From: Daun Johnson <[REDACTED]> on behalf of Planning.Responses
Sent: 04 April 2019 10:31
To: Sian Eggington
Subject: FW: Further Information Required on Your Ref: PP-07739676 Our Ref: M/28/19/HH
Attachments: 202 rev A Existing Plans and Sections.pdf; 204 rev B Proposed Plans and Sections.pdf; 102 rev A Site Block Plan.pdf; Flood map for planning.pdf
Categories: Green Category

From: PAUL REED [REDACTED]
Sent: 04 April 2019 10:21
To: Planning.Responses
Subject: Re: Further Information Required on Your Ref: PP-07739676 Our Ref: M/28/19/HH

SECTION 2
1:100 @ A1

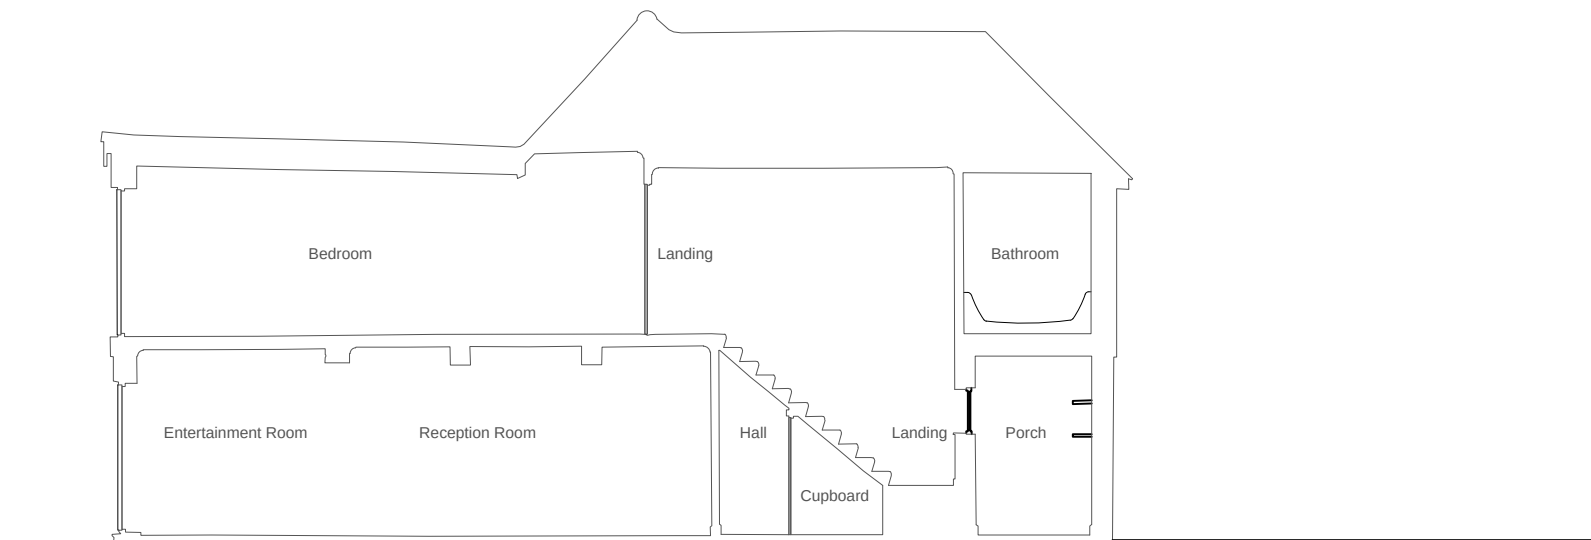
re 2) Block Plan dimensions, please find attached updated block plan showing dimensions, also existing and proposed plans updated showing this in more detail to the side boundary.
